CITY OF PORTLAND, MAINE
DEVELOPMENT REVIEW APPLICATION
PLANNING DEPARTMENT PROCESSING FORM

Hope Ave. Lot #27

From: Jay Reynolds
To: "DReynolds@gorrillpalmer.com"@Portland.gwgwia; Ma...
Date: Tue, Aug 5, 2003 11:40 AM
Subject: Re: Dave Dardano

Drawing Name: **Lot 27 Grading Plan**

Drawing Name:	Lot 27 Site and Utility Plan 5/29/03
Project:	PRESUMPCOT RIVER PLACE

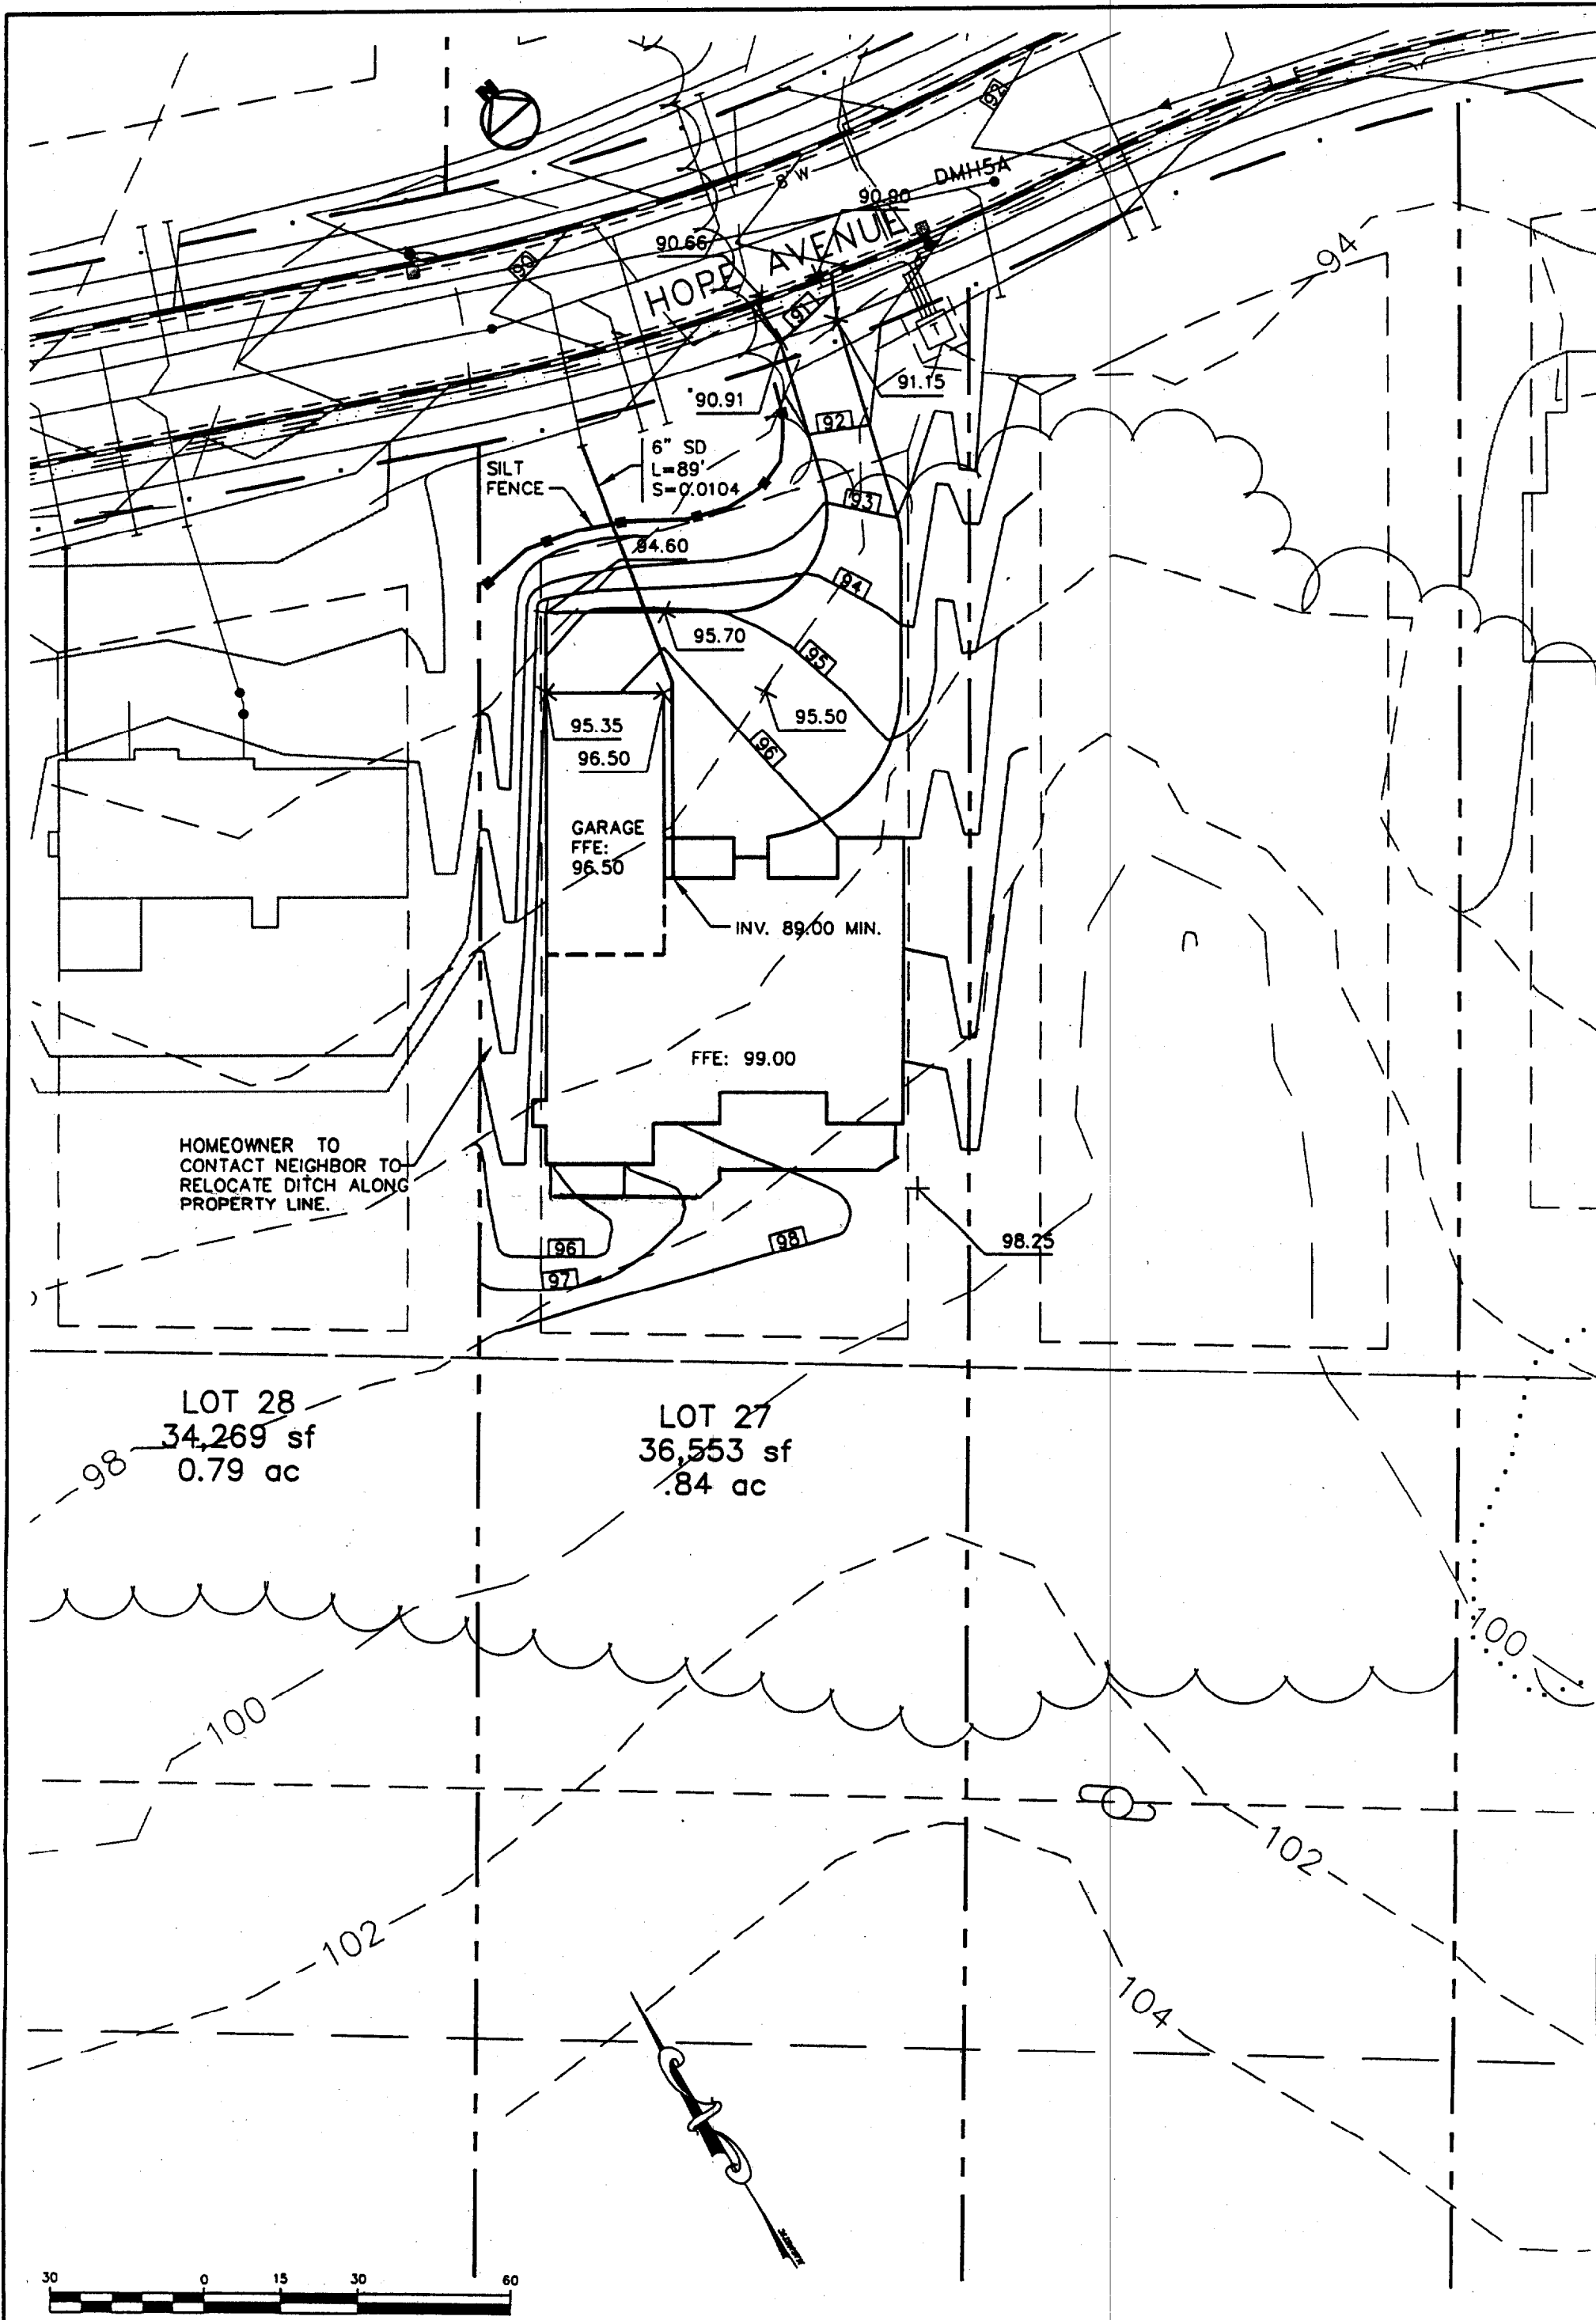
Mr. Dardano just stated he's proposing a Daylight (or half daylight) basement on the side of his house (lot 28 side). This should take care of some of the sideslope issues I was concerned about.

The site plan needs to be revised to reflect this. Mr. Dardano said 3 feet, you should talk to him to clarify these changes. He also stated he wants to drop the grading a little around the garage, but not the garage entrance. I don't need the plan exact, just closer to what's actually going to be built out there. Mr. Dardano may need to submit revised building elevations to the inspections office as well.
